January 16, 2019

RE: Comment Response for Grazing Yak Solar Project, LLC Application for a Wind/Solar Energy Generation Overlay (WSEO), Submittal #1,

LEGAL DESCRIPTION OF THIS WSE-O AREA IS PROVIDED ON SHEET 3

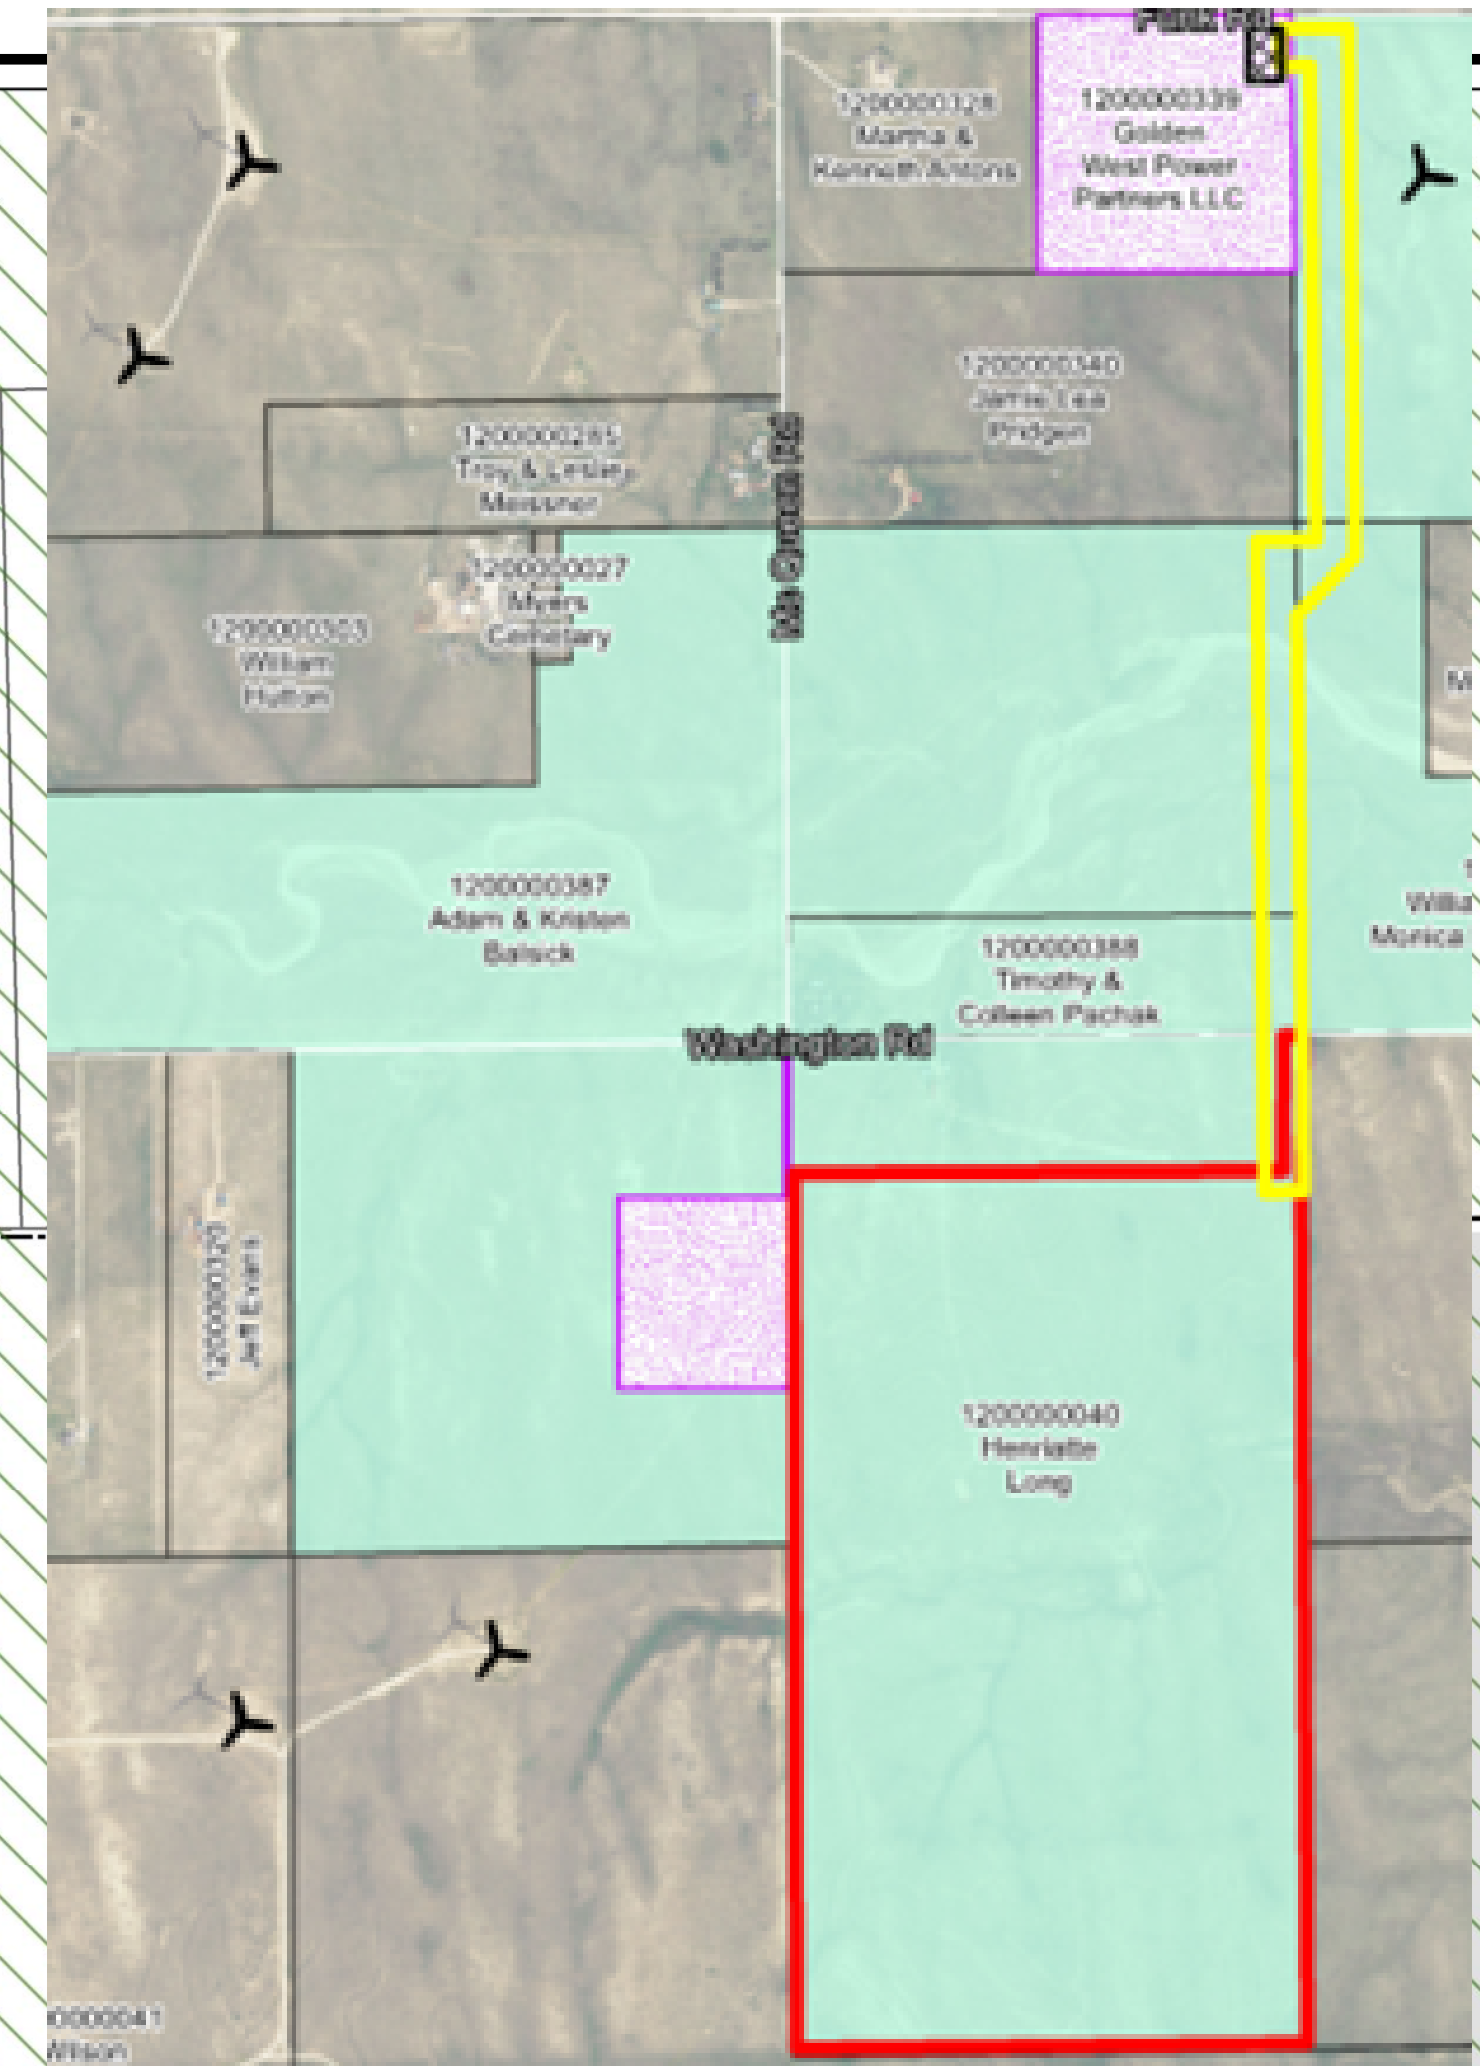
1. Please see redline items uploaded to EDARP. Please revise the items and upload them. A complete review will occur after basic legal and project area is determined. Staff anticipated the WSE-O solar boundary as shown on the submitted zoning map and boundary map. The WSEO plan and application do not match these.

3. The legal should describe the boundaries of the WSE-O for the solar facility, substation and existing or proposed collection lines. If the entire parcel is not to be a part of the WSE-O than it does not need to be included. The area in red, yellow and pink (270 acres) in the boundary map is the area to be included in the WSE-O legal not the entirety of the parcels. Create a 270-acre legal please. All the reports should include the 270 acres.

Response: The WSE-O Plan has been updated to reflect the extent of solar facilities, collection line, substation, and laydown areas in the Project WSE-O boundary. The legal description has been updated to reflect the updated WSE-O boundary.

Response: The legal description has been rewritten to reflect the updated WSE-O boundary of 377 acres which includes the 272-acre solar array, 45-acre collection line corridor, 1-acre substation, and 39-acre and 20-acre temporary laydown yards. All documents listed on EDARP for re-submission at this time were updated for the revised WSE-O zone and acreage. All other reports in the WSE-O application mentioning
